From: Contact Centre (CRM) <contact@ribblevalley.gov.uk>
Sent: 31 May 2022 22:12
To: Planning
Subject: Planning Application Comments - 3/2022/0432

Planning Application Reference No.: 3/2022/0432

Address of Development: Feildens Arms,

Planning Application 3/2022/043 Feildens Arms Whalley Road Mellor Brook Planning Officer Kathryn Hughes.

TITLE:	Location and Block Plan
--------	-------------------------

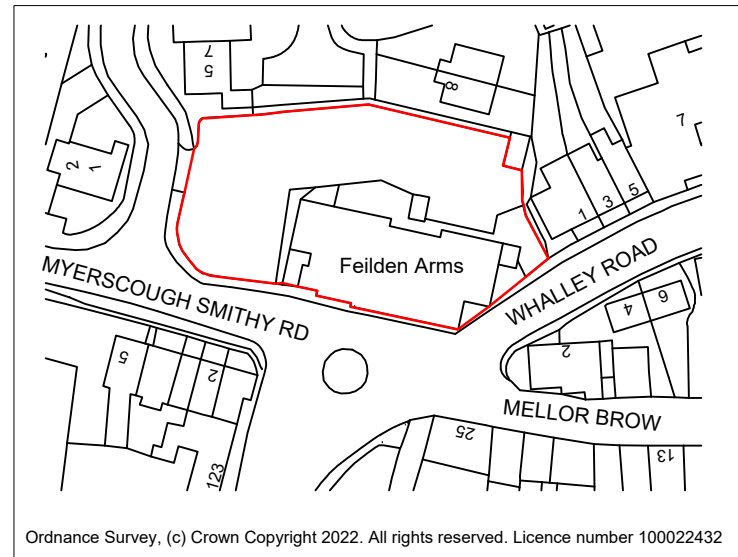
- The strict limits on car parking spaces in the proposal do not allow for a further increase in covers, with overlap which will increase the need due to the perceived change from a greater dining only experience to that of a drinking establishment. This would strongly suggest (as public transport is infrequent) that car park spaces are inadequate to also cater for additional staffing requirements. It follows that some drivers will park on the adjoining narrow road which is unsafe & unacceptable, blocking residents driveways. The adjoining junctions are blind to traffic travelling along Whalley Road to Mellor Brow. Any additional risk of accidents should to be avoided.

[REDACTED] think it's a great idea that the pub is done up as it's a great asset for Mellor Brook, but reducing the car park to 30 parking places and increasing the covers to 200 will undoubtedly mean more people will park on Feildens Farm Lane.

The public house car park is not large enough for the number of visitors anticipated

PROPOSED GROUND FLOOR PLAN

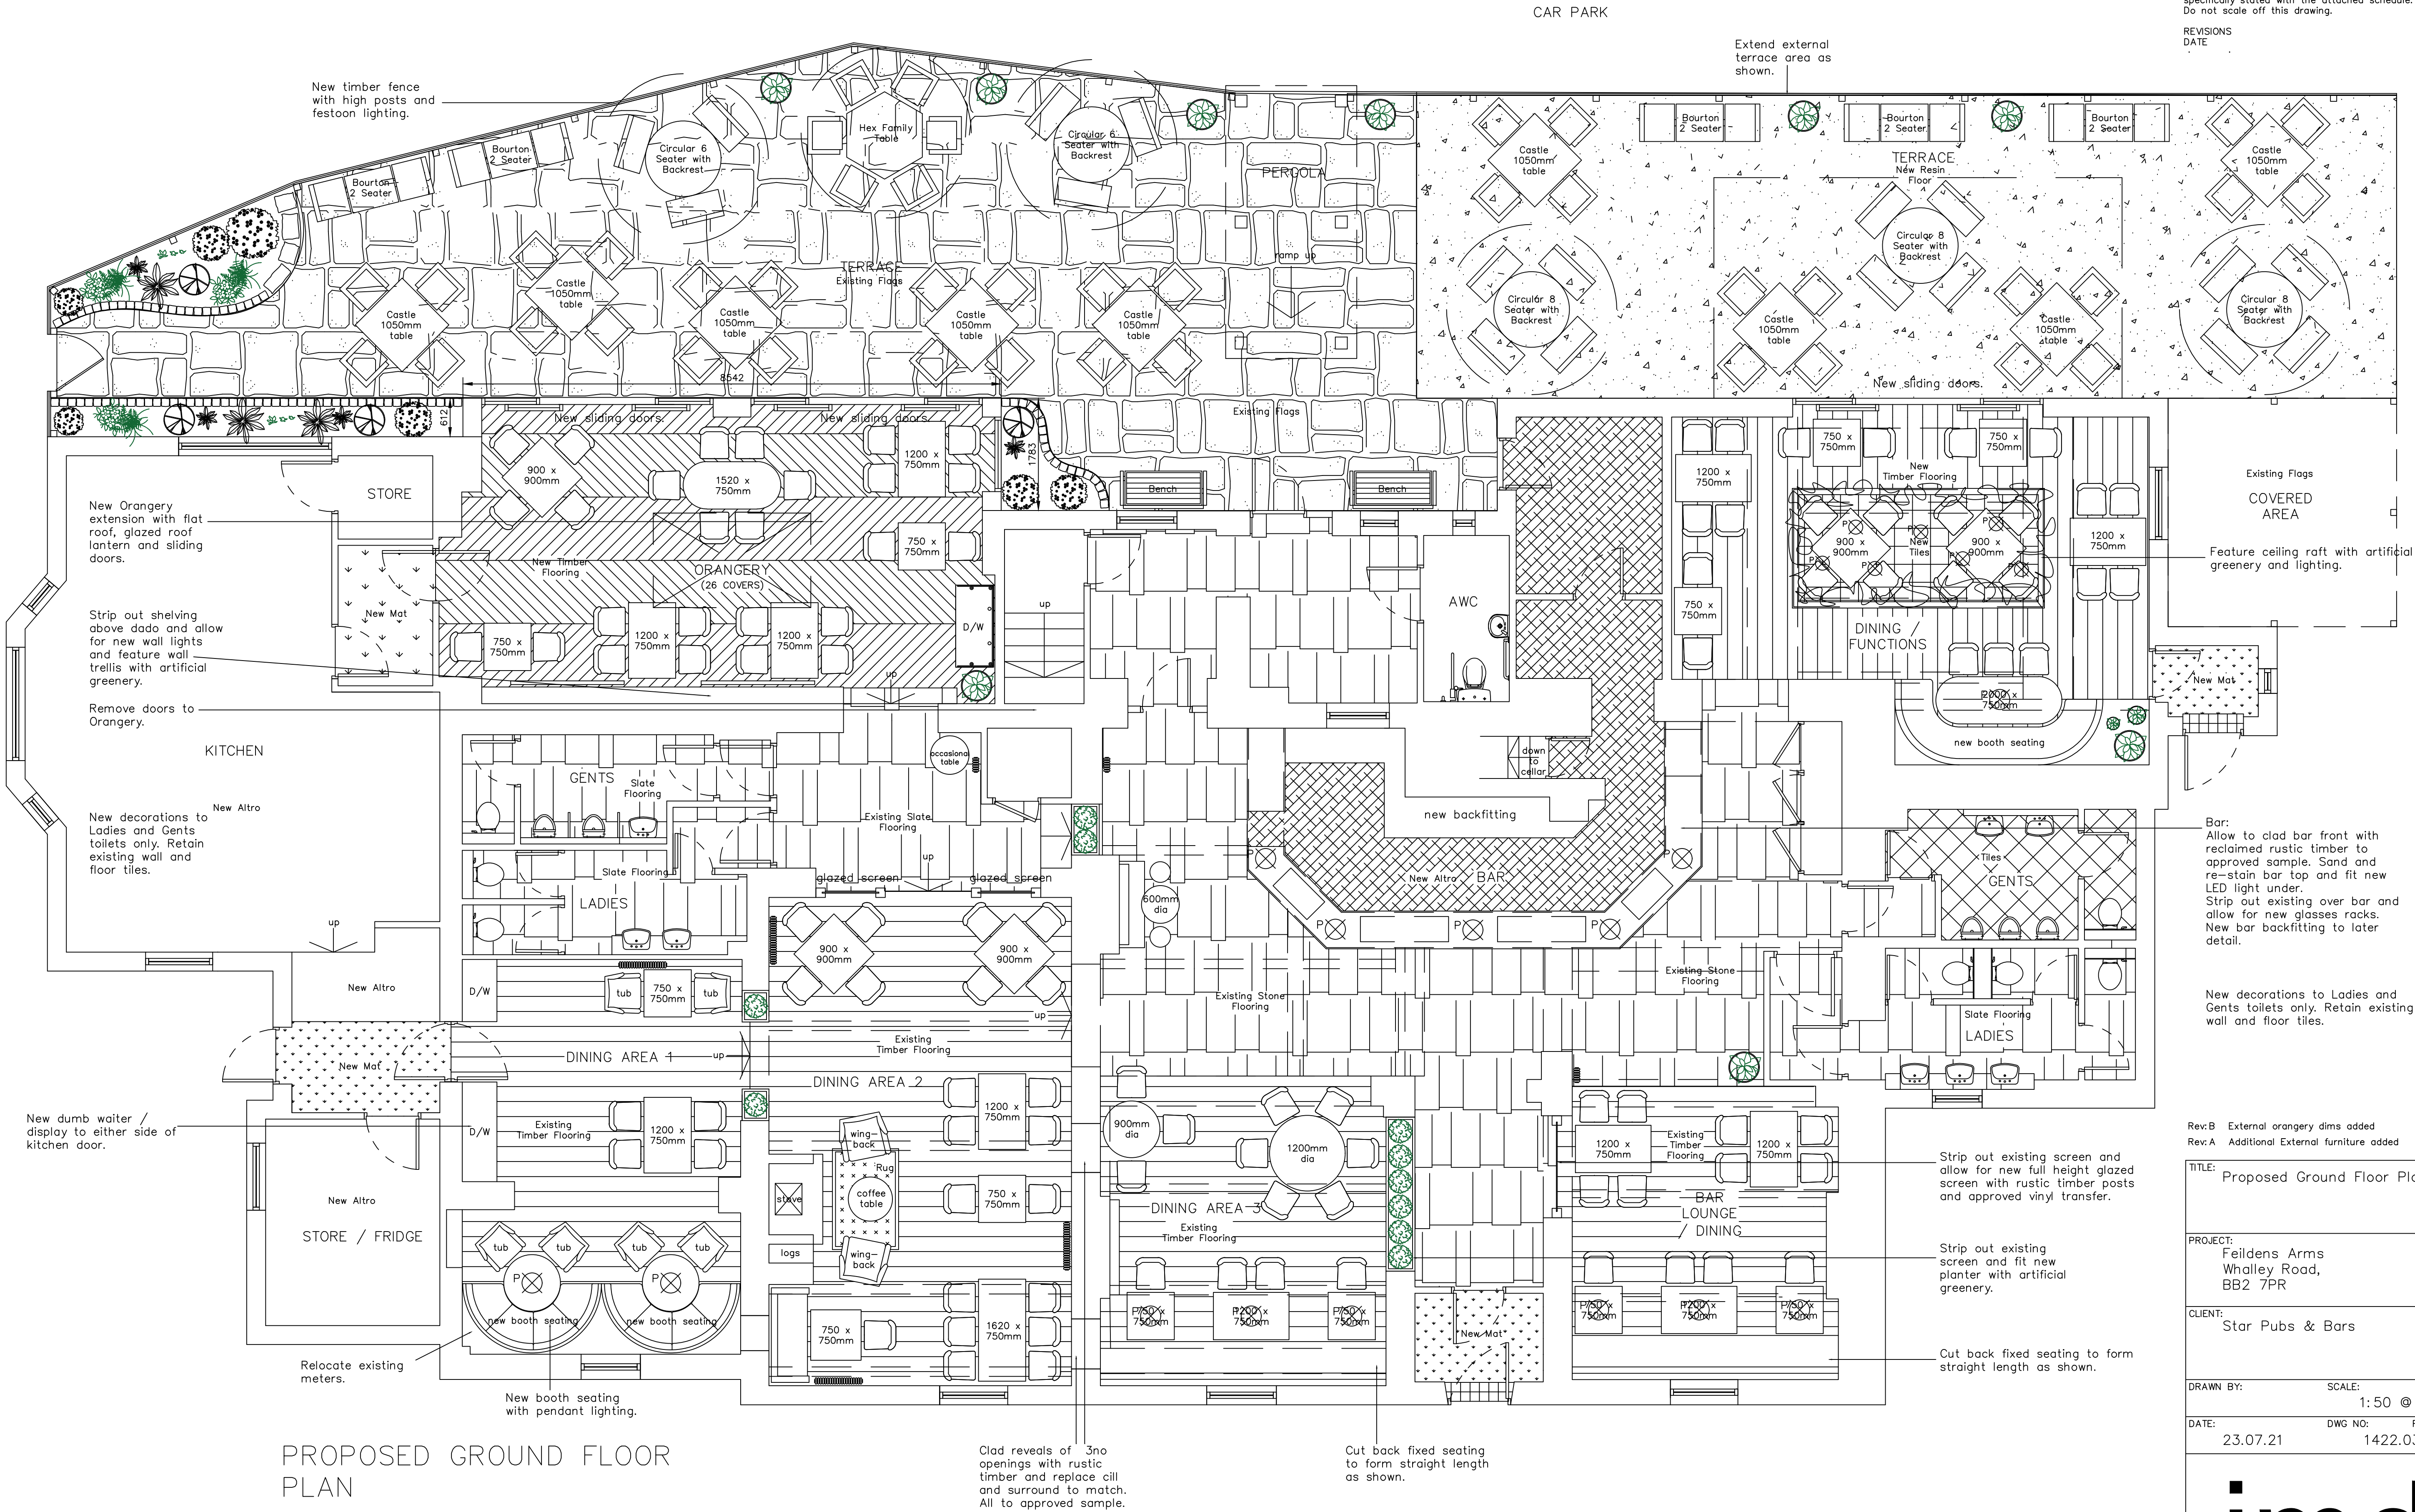
- A larger outdoor eating area would impact local residents combined with the fact that the premises are proposed to be open 7 days per week. The increase in noise pollution is unacceptable for local residents.

- The proposed additions to the overall footprint of the site would have a negative impact on the local properties, restricting the residents' rights to privacy & lack of disturbance in their own homes & gardens, which is unacceptable.
